WELWYN HATFIELD BOROUGH COUNCIL – DEVELOPMENT MANAGEMENT
DELEGATED REPORT

APPLICATION Nos : S6/2014/142/MA & S6/2014/143/LB

SITE ADDRESS: ESSENDON COUNTRY CLUB, BEDWELL PARK

‘Erection of single storey extension within internal courtyard and formation of door openings within existing window frames and formation of 2 terrace areas to listed building’

PROPOSED ELEVATION B

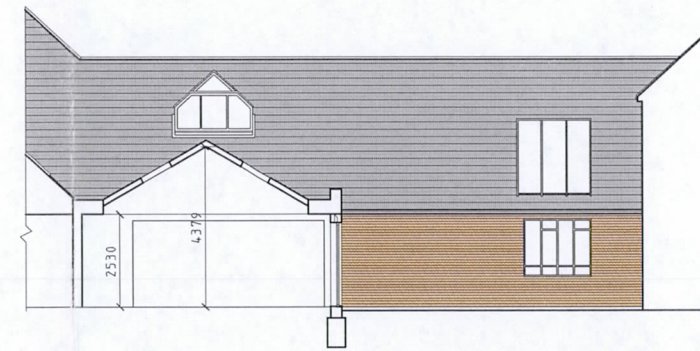
This roof slope shown on 'Proposed Elevation B' on drawing No. 412913/2 is out of character with the other roofs of the building and so there would be no objection to the new roofing material, subject to the approval of this by way of a planning condition.

PROPOSED ELEVATION D

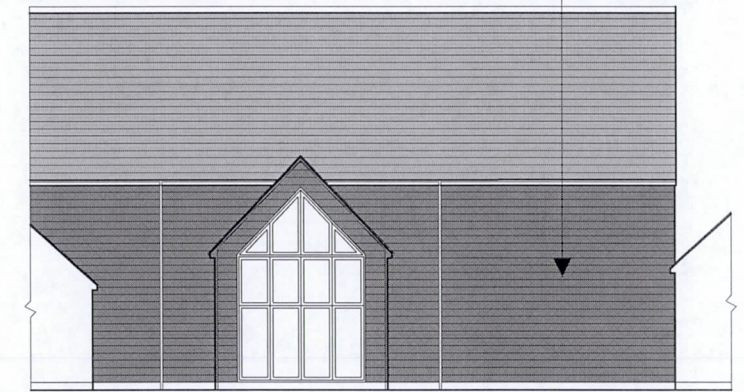
The new glazing shown on Elevation D will also be an improvement compared to the existing and so this is acceptable. No objection was given at the pre-application stage to this new revised glazed screen in the existing main barn which would look out onto the new raised external terrace.

PROPOSED COURTYARD PLAN

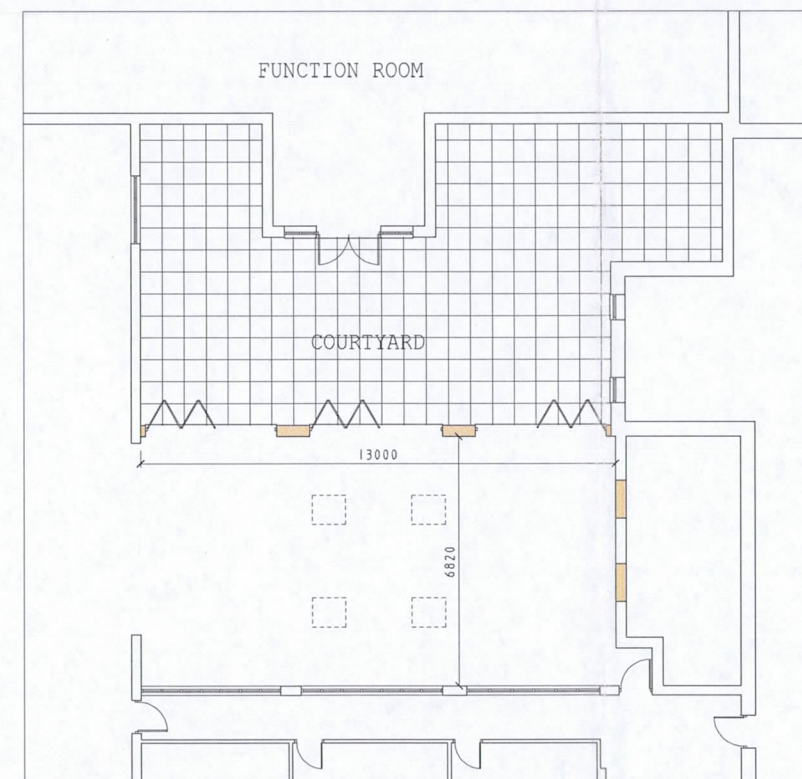
This new single storey extension is to have a separate ridged roof (set within a flat roof area), aligning with the projecting corner of the barn opposite. This would result in leaving an open outside gap of approximately 5.3m from the glazed wall of the projecting bay that projects from the main barn to the new external wall of the extension. This remaining space is considered to be sufficient to maintain a balance between the open outside area and also to allow the setting of the main barn to be appreciated from the open courtyard area.

Close attention to the proposed materials and detailing is necessary with the external walls of the new extension needing to be timber shiplap weather boarding to match the existing main barn, and with roof tiles to also match the existing ones. Windows/glazed doors of the new extension which will look out onto the courtyard need to be timber framed.
